Loreto School Redevelopment – Modification 2 (SSD-7919-Mod-2)  
**Response to Submissions**

West Elevation - Reduced S4.55 Plant
1:100

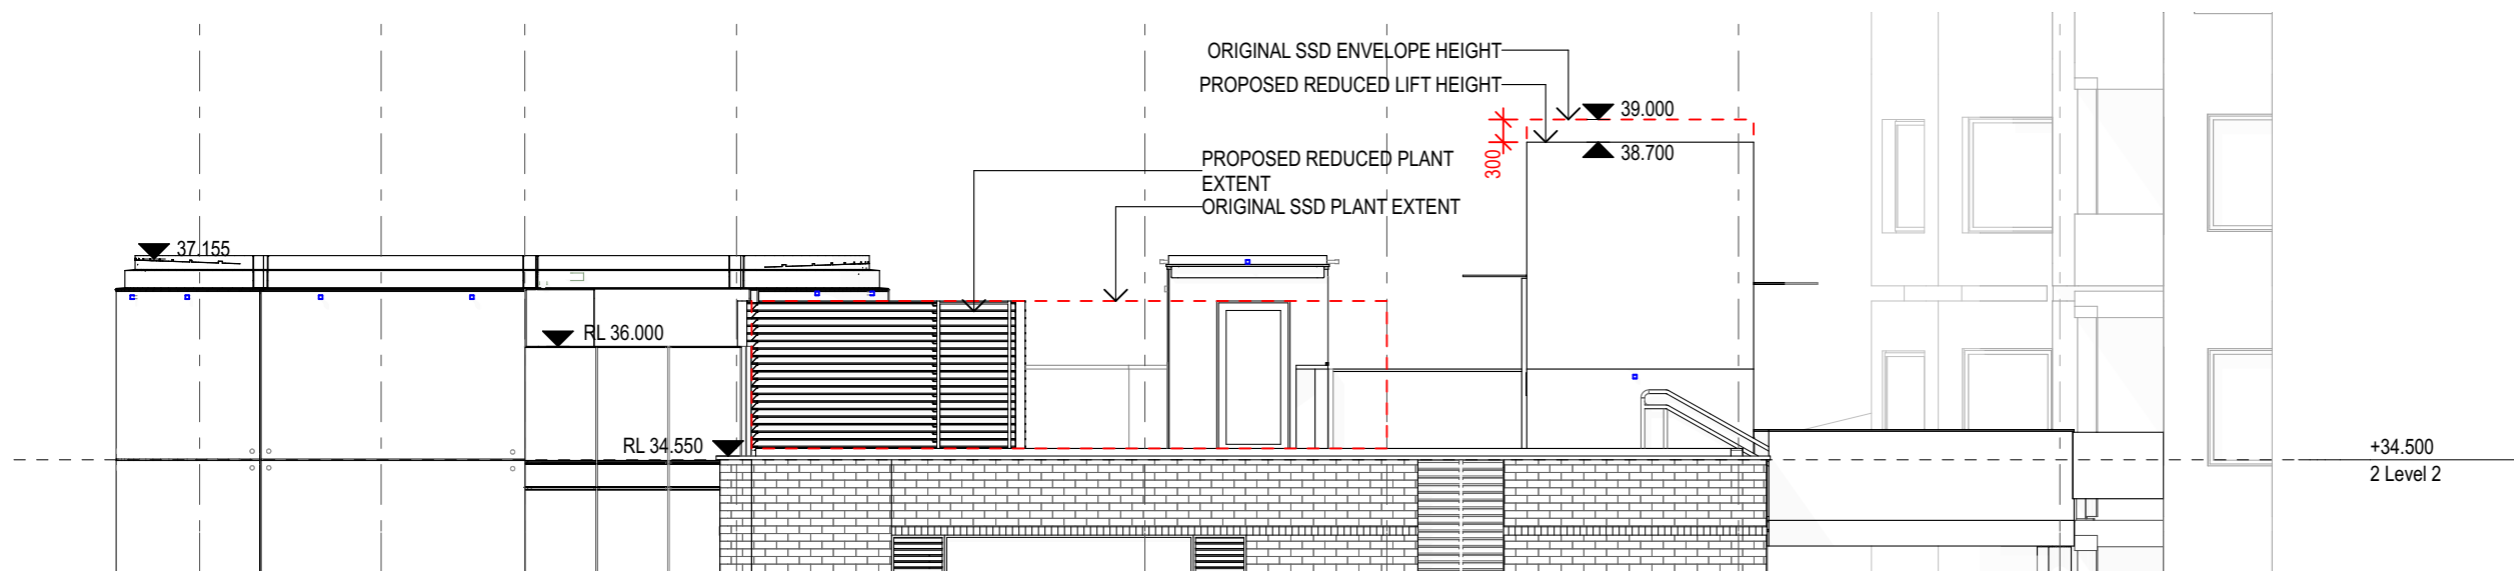
The Department raises strong concerns that the proposed changes to the materiality of the lift overrun (from a transparent glass to concrete) would result in an adverse impact on the sky views enjoyed by the residents on the western side of the site (at 111 Carabella Street).

The Department's view impact assessment of the original proposal concluded that the transparent material of the lift overrun would assist in retaining the visual permeability and sky views for the affected neighbours. However, the proposed modification would not result in improving this previously assessed outcome. As a result, the Department considers that the proposed material of the lift overrun should be converted to a transparent material like glass (as previously approved).

Otherwise further justification should be provided as to why the proposed materiality change would result in a better outcome for the proposal, in terms of the view impacts.
